Application H16-0397-18
Location Horseshoe Road Spalding PE11 3JA
Proposal Details of Contamination and Archaeological Investigation (Conditions 2, 3, 4 and 5 of H16-0715-16)

H16-0397-18 - Horseshoe Road, Spalding PE11 3JA

Figure 2: Site location at an original scale of 1:500, (not to scale), (extract from Architects plan)

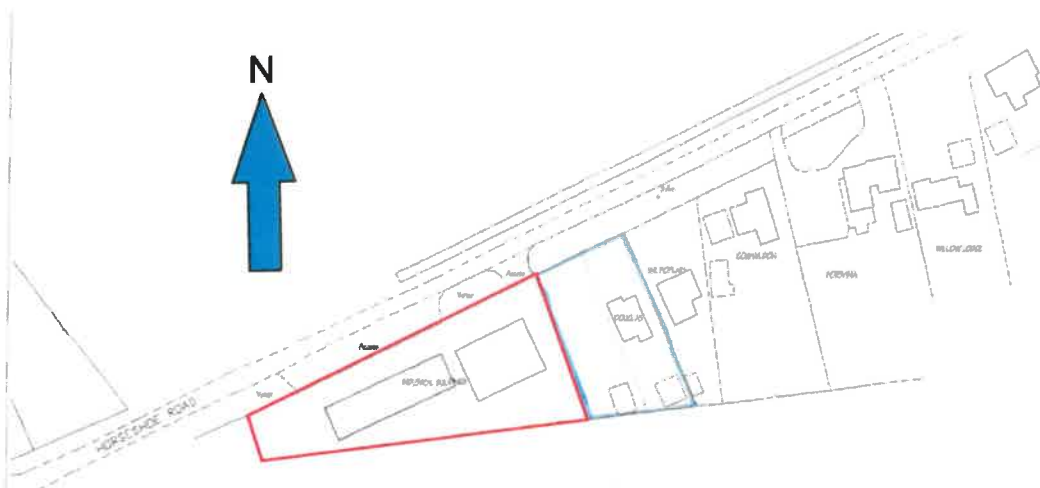
The report identified some samples with levels of contaminants above the selected screening values for residential end use, but stated that the samples in question were all from under areas of hardstanding. This appears to differ from the plans supplied.

However, the report also notes that site levels are to be raised by some 500mm relative to the current land level. Given the levels of contaminants present, and the increase in site levels, I agree that future users will be adequately protected, provided the area of WS3 is definitely below hardstanding. Verification of imported soil, and before/ post site levels will be required to be submitted in order to fully discharge the condition. Attention should be drawn to YALPAG Guidance 'Verification Requirements for Cover Systems' for acceptable levels of verification.
